**KIRKLEES COUNCIL  
TOWN AND COUNTRY PLANNING ACT 1990  
STREETSCENE & HOUSING  
LANDSCAPE SECTION**

PLANNING REF: 2018/91661

<b>PROPOSAL:</b> Outline permission for residential development and facilitating engineering operations and full planning permission for access and spine road	Ref. No.	GG99
	Officer	EM
	Tel No.	01484 221000/ 07890 630 720
	O.S. Ref.	<b>SE421952423120</b>
<b>LOCATION:</b> Land at Walkley Terrace and Brunswick Street, Heckmondwike	Date Received	19/07/2018
	Date Returned	6 June 2018
	Site Area	2.5 ha

**DEVELOPER/APPLICANT/AGENT : Vida Architects Ltd**

Key

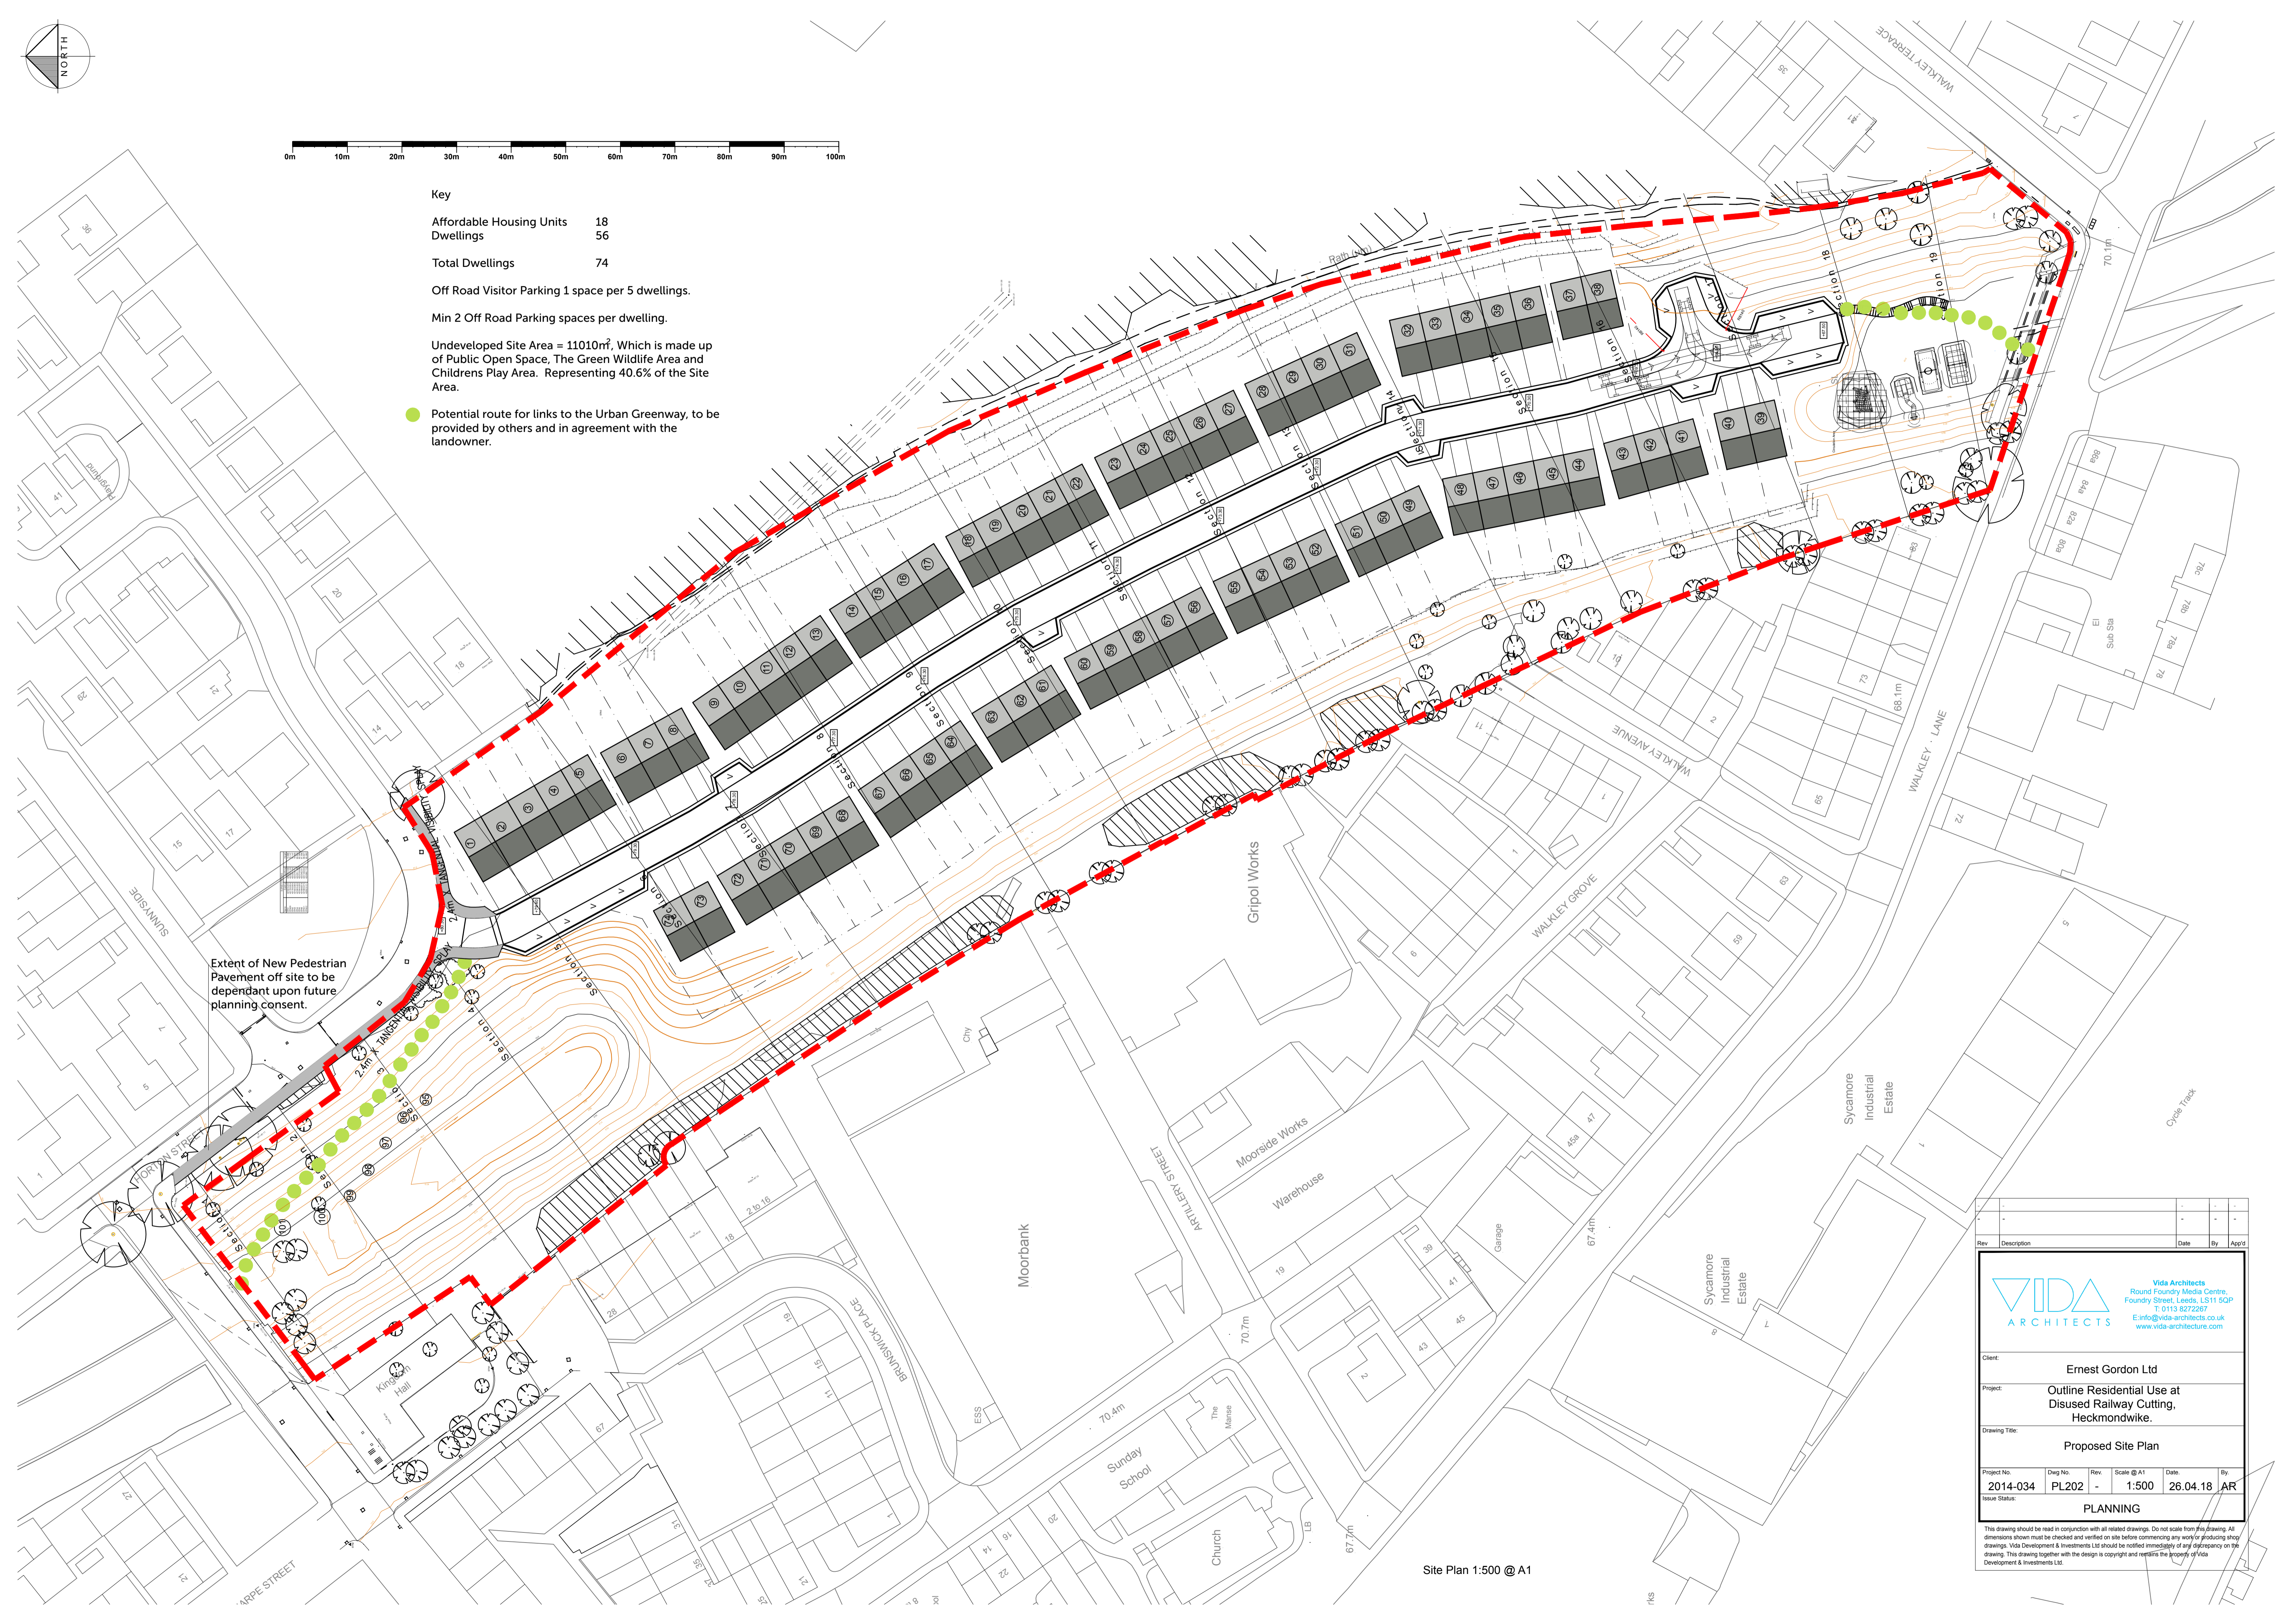
The area of Public Open Space (POS) based on 74 dwellings, should be a minimum of 2220 sq. m. which should be accessible and useable as amenity space for the wider public. There appears to be provision of pos with this application although more detail and clarity required about its usability as accessible amenity open space. There is a sketch of an area of play equipment at the south end and just an open area at the north end. Whilst the provision of the greenway route and linking paths will be a bonus for this site, POS should provide accessible amenity playable spaces, which will not cause nuisance to residents or those parking adjacent to the areas. Levels and accessibility plans will be required together with further details of any seating bins and footpaths serving the pos. Incidental landscaped areas or highways verges do not constitute amenity POS.

Within the 2220 sq. m of pos provision required as amenity open space, this number of dwellings would also require an equipped play area, a Local area of play (LAP) in accordance with 'Fields in trust' Guidelines. In lieu of this being on the site we would ask for an offsite contribution to an existing play facility, to improve the neighbourhood play facility, potentially Cawley Lane Rec to the east (currently just over 700m walk away to east but potentially closer if new link paths are incorporated). The requirement for the site would be an area of play space, potentially incorporating natural play elements, and in this instance would require a no prejudice offsite contribution of approx. £196,950 (This includes a commuted sum for maintenance of the play equipment/surfacing).

- Details for disposal of any waste arising from works
2. The Council considers a presumption in favour of tree planting in verges and adjacent to carriageways in line with the West Yorkshire Combined Authority 'Green Streets ®' principles, unless there are valid reasons for their omission. Tree planting is very important, and getting the right types and size of trees in the right places is imperative. Trees should be incorporated in the scheme for a variety of reasons: to a) visually break up the built form b) help to screen/mitigate or frame certain views c) support biodiversity and create green corridors/green links, d) not to create a nuisance in peoples gardens through leaves in gutters or screen the sun etc. e) not to cause damage to property boundaries/garden fences/dry stone walls in the future, or damage any SuDS system. There are opportunities for tree planting within the site and this will help mitigate the scheme.

4. The scheme will need to demonstrate clearly where bin storage AND collection points are, each dwelling will require 2 no. containers- at least 1 x 240ltr grey & 1 x green 240ltr. Also indicate the location of proposed grit bins. It is important that a functional facility for refuse collection is included.
